STATE OF NORTH CAROLINA
DEPARTMENT OF TRANSPORTATION
MAP OF PROPOSED PROPERTY OF
TOWN OF WILKESBORO

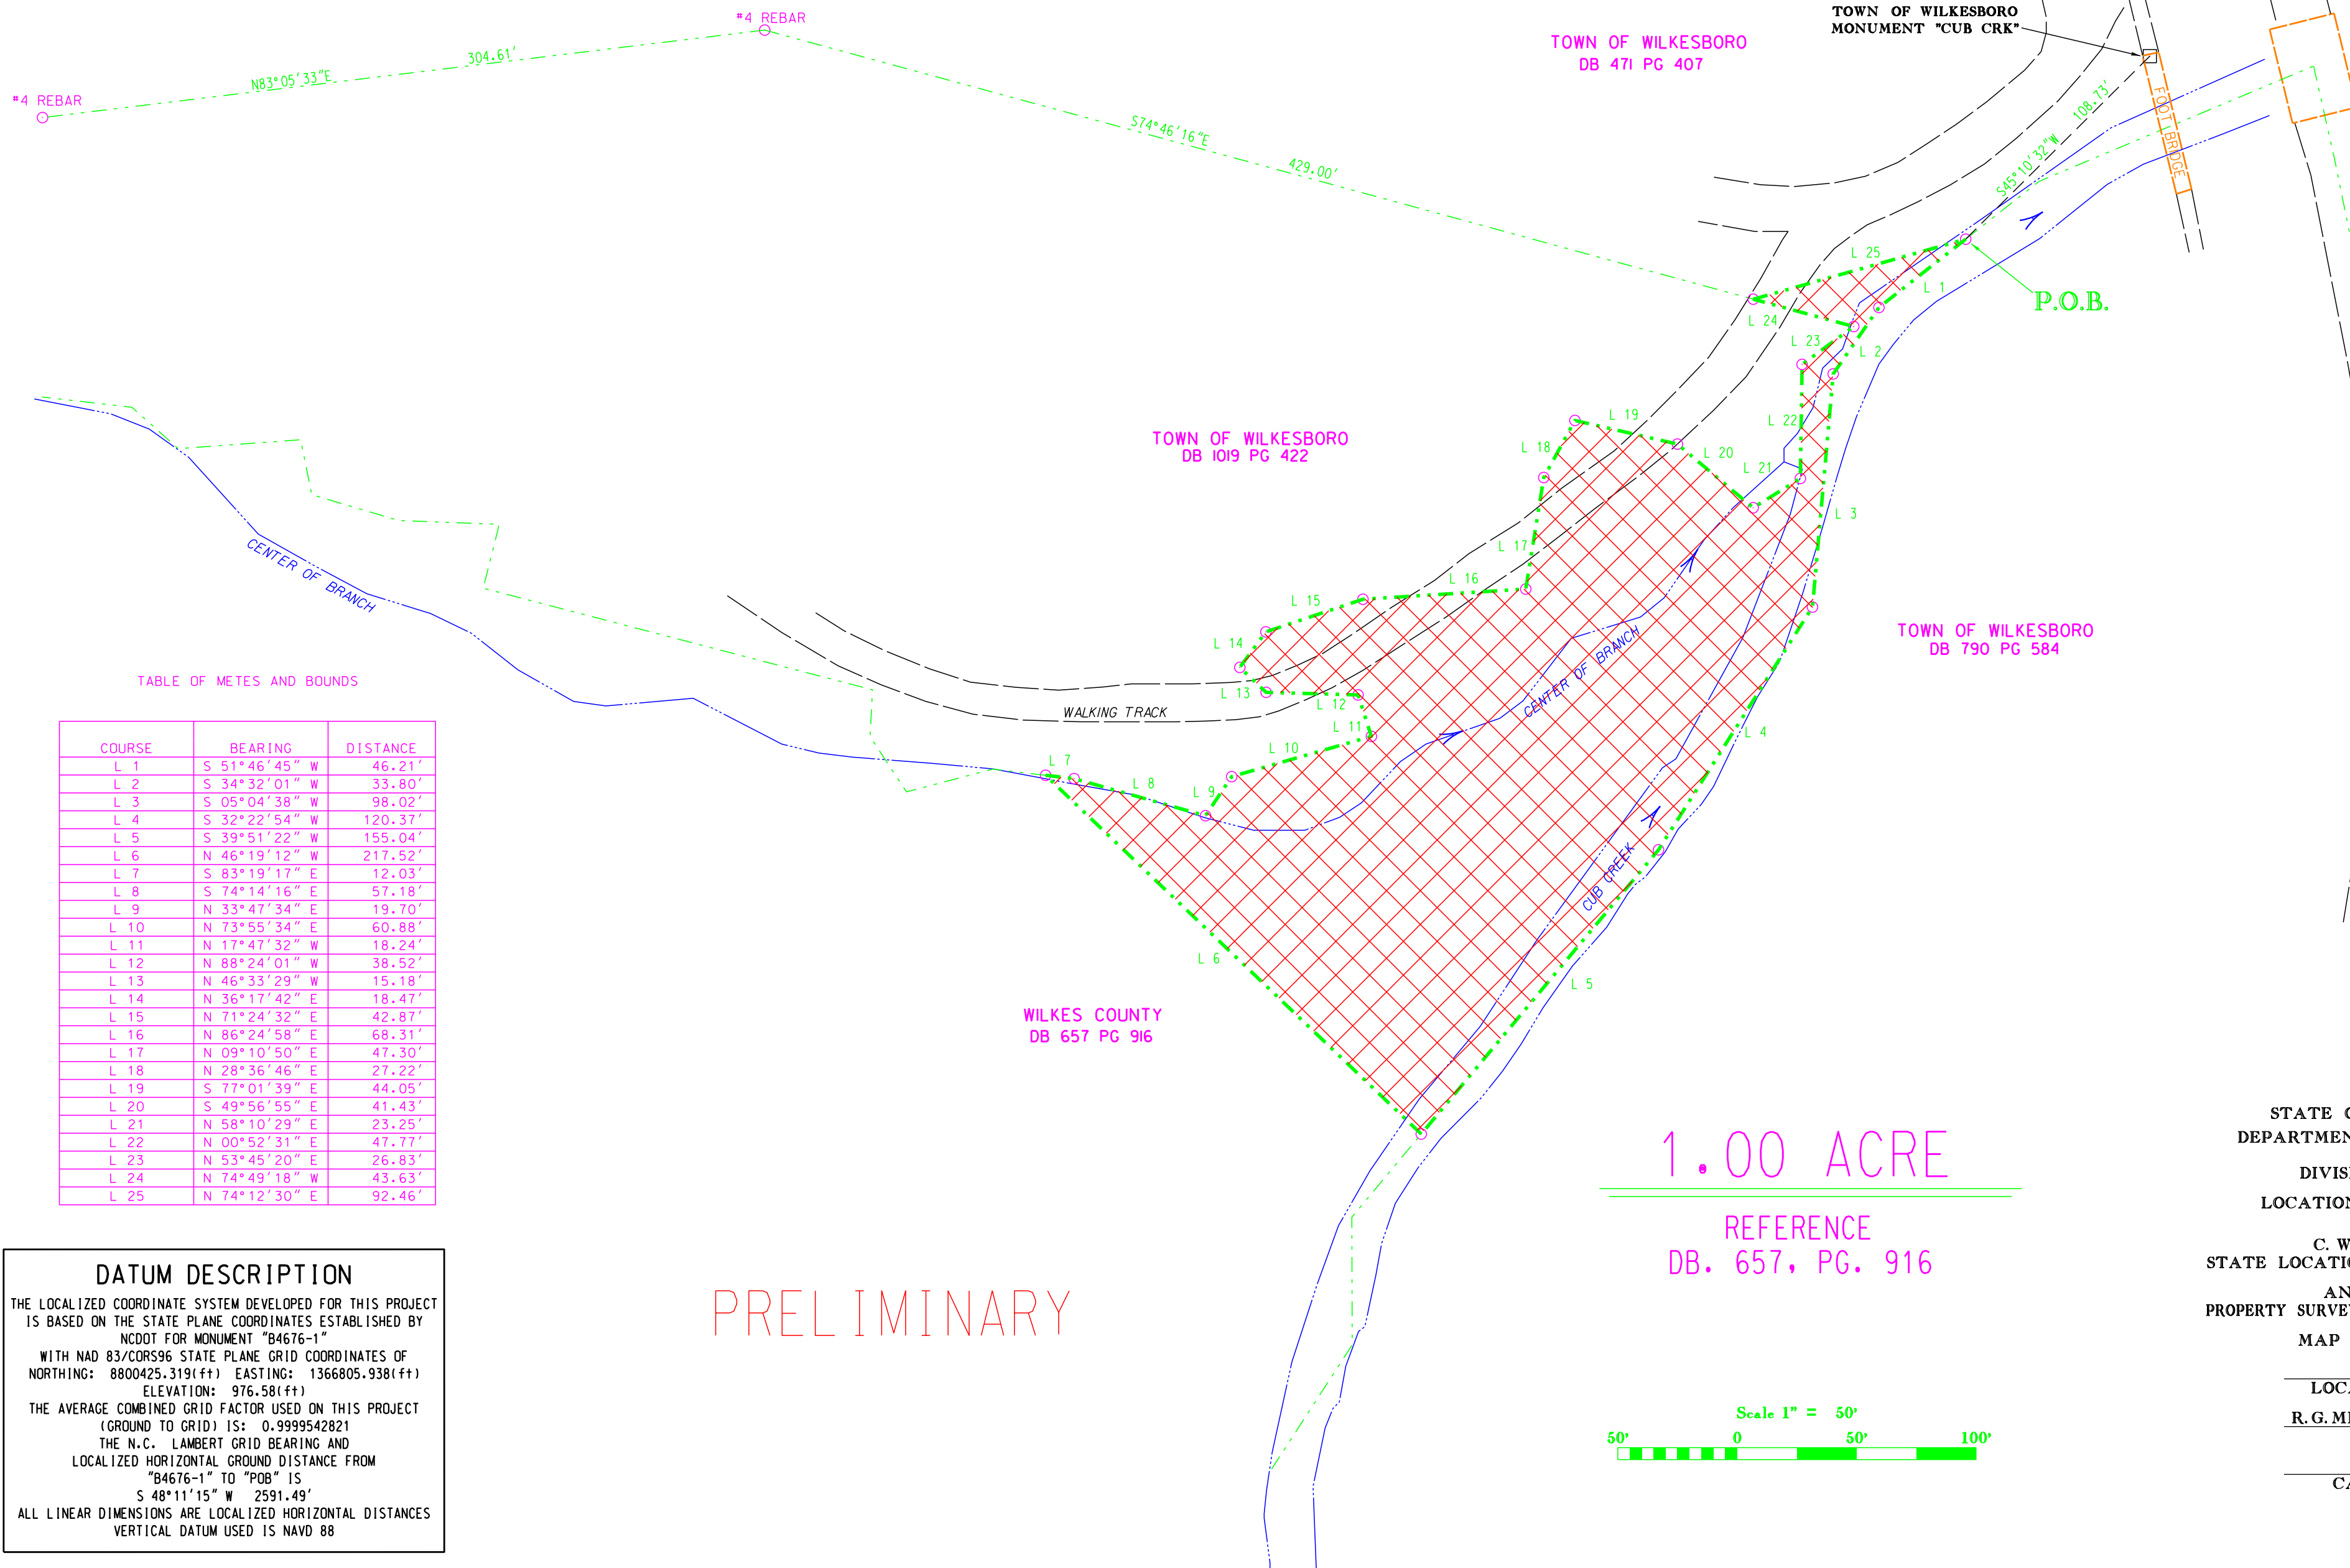
Not included (needs to color coded w/notes/bound for 1) converted & 2) remaining park land

color code where on maps the replacement tract is

will be revised to reflect the converted and replacement tracts (see attached 6(f) maps)
